**Planning Act 2008 – Section 88 and the Infrastructure Planning (Examination Procedure) Rules 2010 – Deadline 6: Comments on Applicant's revision 5 draft DCO**

**Application by NNB Generation Company (SZC) Limited for an Order Granting Development Consent for the Sizewell C Project**

## Appendix A: Environment Agency comments on Draft Development Consent Order

PROJECT:
SIZEWELL C

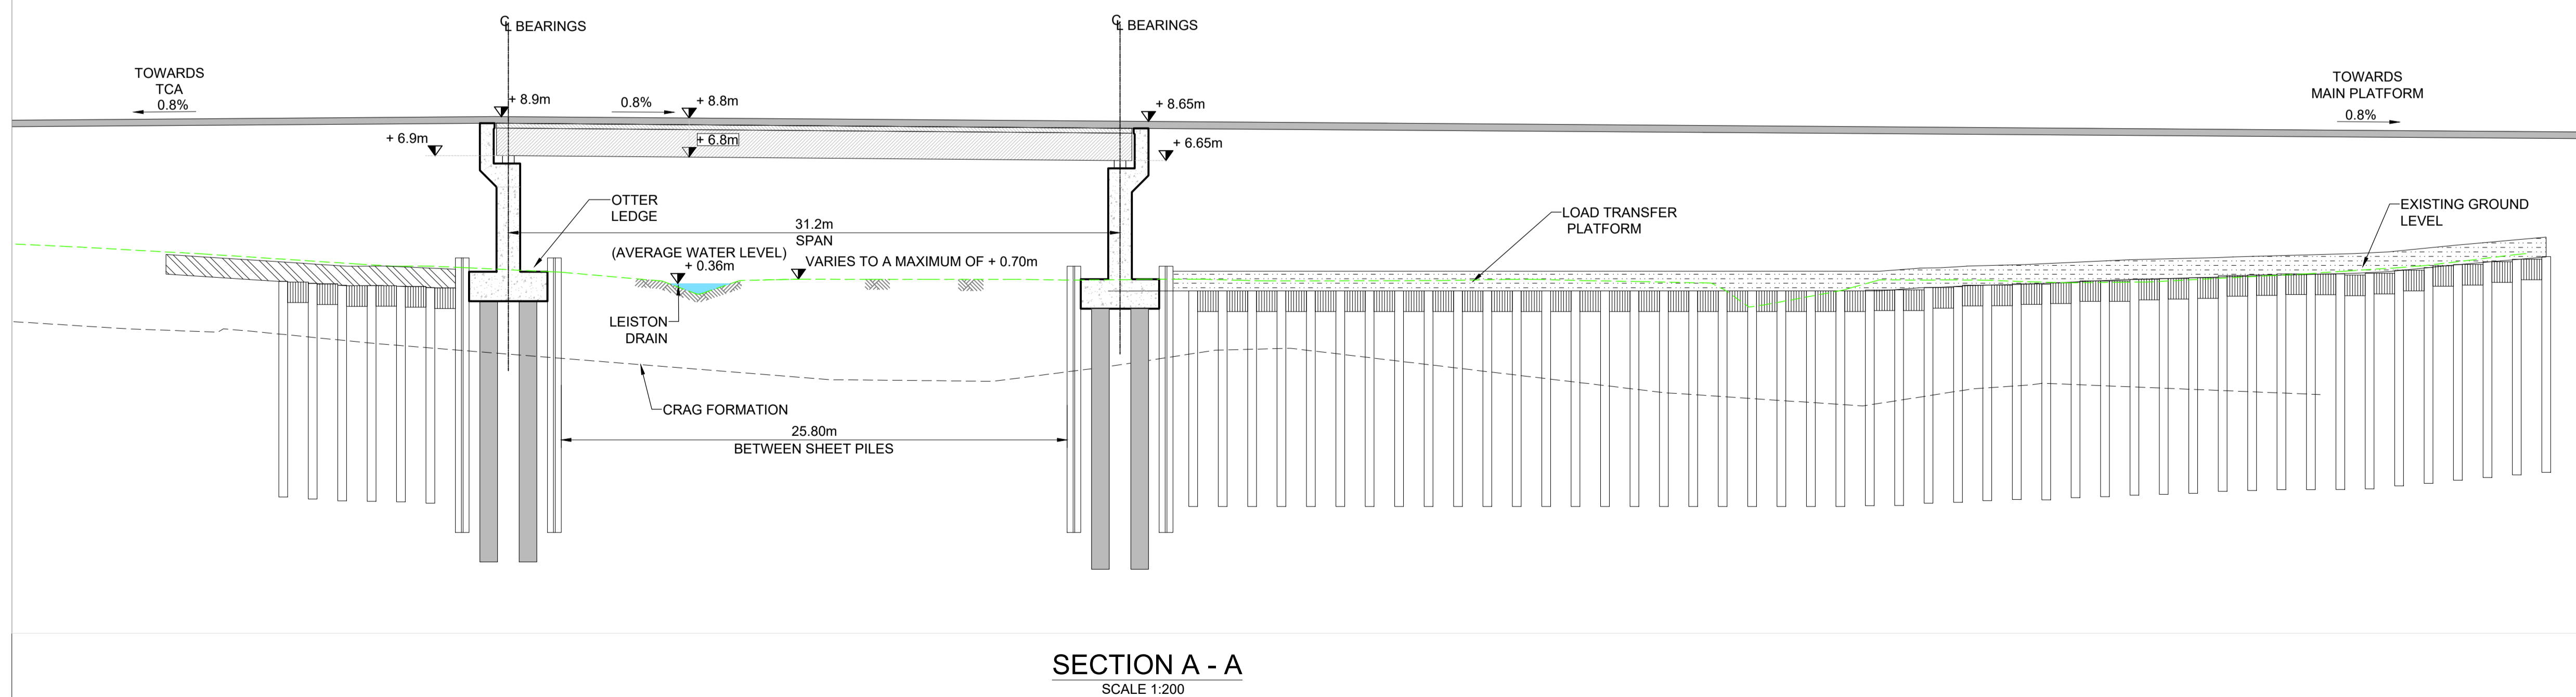
Section	Wording	Comments
<b>Schedule 2, Article 3 - Requirements</b>		
Requirement 12C,  Main development site: SSSI Crossing	<p><b>Main development site: SSSI Crossing</b></p> <p>(1) Construction works within the SSSI must not commence until details of working methods within the SSSI land have been submitted to and approved by East Suffolk Council, following consultation with Natural England. The temporary SSSI Crossing must be built in general accordance with the following details:</p> <p>(a) Main Development Site SSSI Crossing (SZC Construction) (July 2021) (Drawing Ref: SZC-SZ0100-XX-000-DRW-100207 (Rev. 02));</p> <p>(b) Main Development Site SSSI Crossing (Bailey Bridge Stage) (July 2021) (Drawing Ref: SZC-SZ0100-XX-000-DRW-100209 (Rev. 02)).</p> <p>(2) Construction of the permanent element of Work No. 1A(I) (SSSI Crossing) must not commence until details of the layout, scale and external appearance have been submitted to and approved by East Suffolk Council, following consultation with the Environment Agency and Natural England. The details must:</p> <p>(a) be in general accordance with the Main Development Site SSSI Crossing (SZC Operational) (July 2021) (Drawing Ref: SZC-SZ0100-XX-000-DRW-100205 (Rev. 02));</p> <p>(b) include layout and scale which has:</p> <p>(i) a crest no lower than 8.6m (AOD);</p>	<p>The potential environmental impacts, including Water Framework Directive concerns, relate to both the construction and permanent elements of the SSSI Crossing.</p> <p>On this basis, we request that the Environment Agency is a consultee in discharging (1) Construction works, as well as for (2) permanent elements.</p>

<p>(ii) a soffit no lower than 6.8m (AOD) at its intersection with the Leiston Drain; and</p> <p>(iii) a span no wider than 15m.</p> <p>(c) include a flood risk monitoring and adaptive defence plan that sets out the periodic monitoring proposals for the SSSI Crossing and the trigger point for when the crest height of the SSSI Crossing would need to be increased to 10.5m (AOD).</p> <p>(d) a timetable for the works, including a timetable for the return of temporary SSSI land.</p> <p>(3) Work No. 1A(I) (SSSI Crossing) must be carried out in accordance with the approved details.</p>	
<p>Requirement 22A,</p> <p>Associated developments: Landscape works</p>	<p><b>Associated developments: Landscape works</b></p> <p>(1) Work No. 11 and Work No. 12 must not be commenced until details of the landscape works for that work have been submitted to and approved by East Suffolk Council.</p> <p>(2) The details referred to in paragraph (1) must be in accordance with the Approved Plans (Schedule 7), unless otherwise agreed by East Suffolk Council.</p> <p>(3) Landscape works must be carried out in accordance with the approved details.</p> <p>(4) landscape works in relation to Work No. 11 must be managed in accordance with the Two Village Bypass Landscape and Ecology Management Plan, unless otherwise agreed with East Suffolk Council.</p>	<p>This requirement secures key environmental mitigation and monitoring measures.</p> <p>On this basis, we request the requirement is amended so the Environment Agency is a consultee any future revision of Sizewell Link Road or Two Village Bypass Landscape and Ecology management plans.</p>
